Planning Application A/76/15/PL and A/77/15/L
Angmering Manor, Angmering.

This application is similar to previously refused applications and our objections are along the same lines.

Title
ADDITIONAL GARDEN BEDROOMS
ELEVATIONS

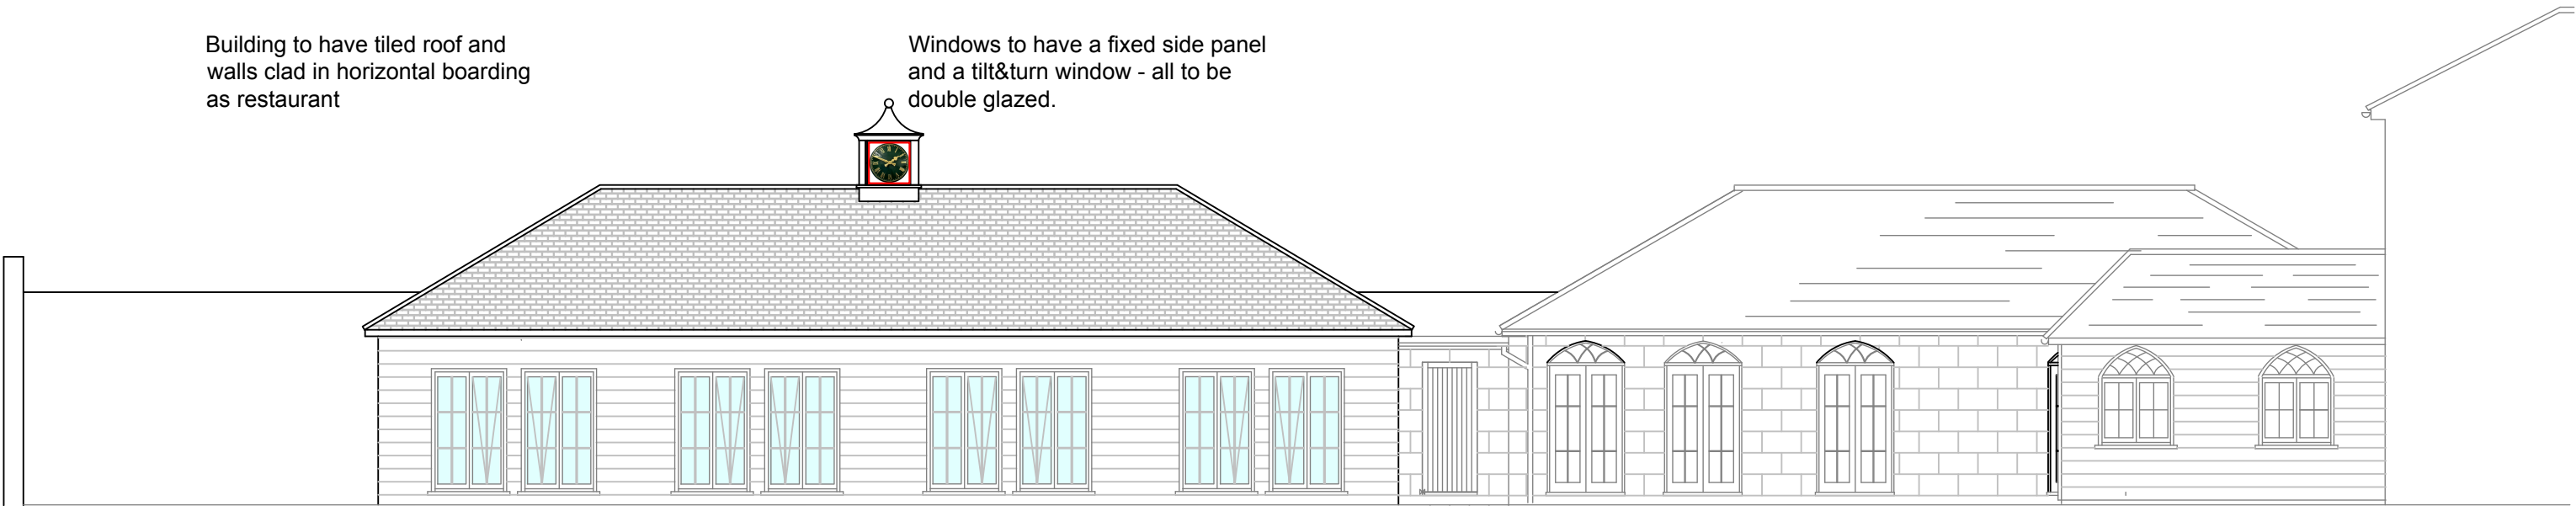
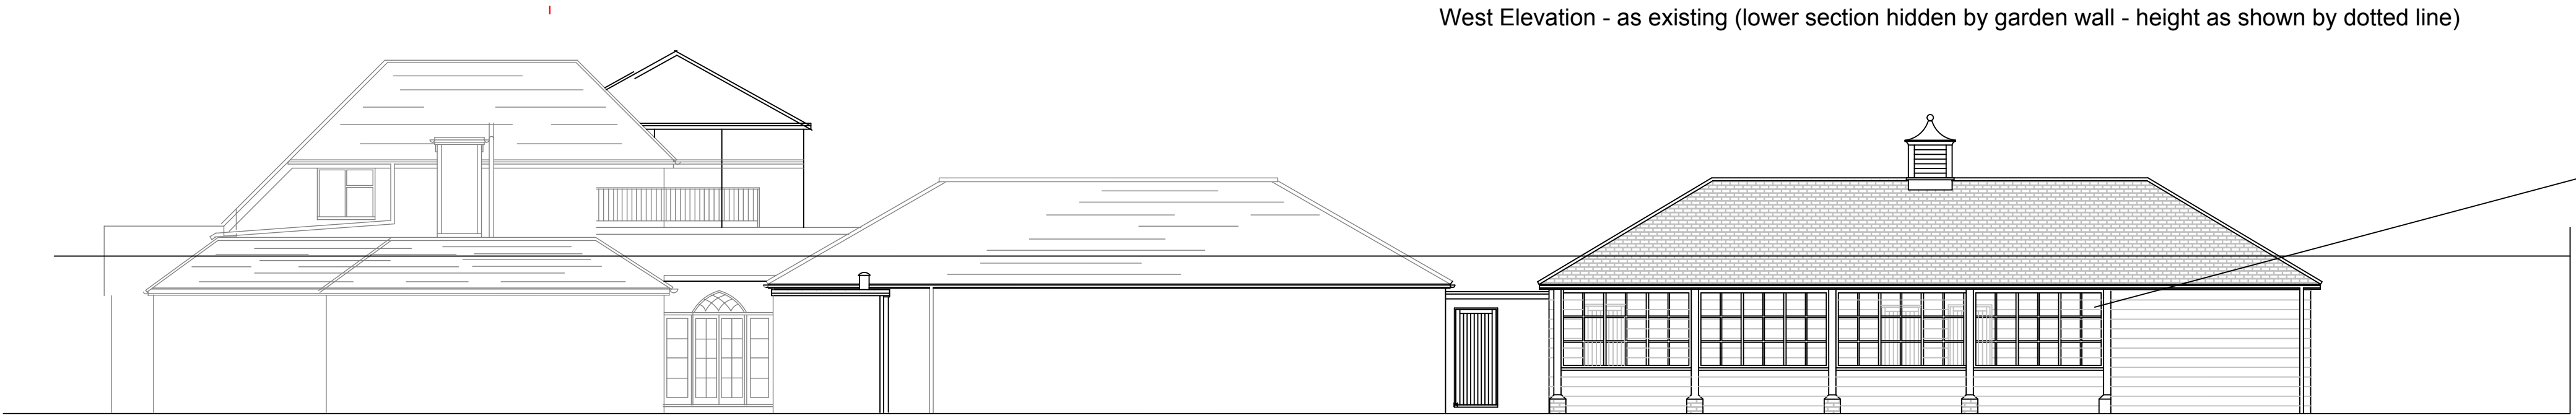
The condition on the garden states there is to be no outside use after 9.0pm. It would be impossible to monitor guests use of these proposed rooms. Any noise would be heard by local residents in the very close proximity.

The removal of so much greenery in the front of this property will have a vast effect on this beautiful stretch of road in this Conservation area. Noise levels will also be increased.
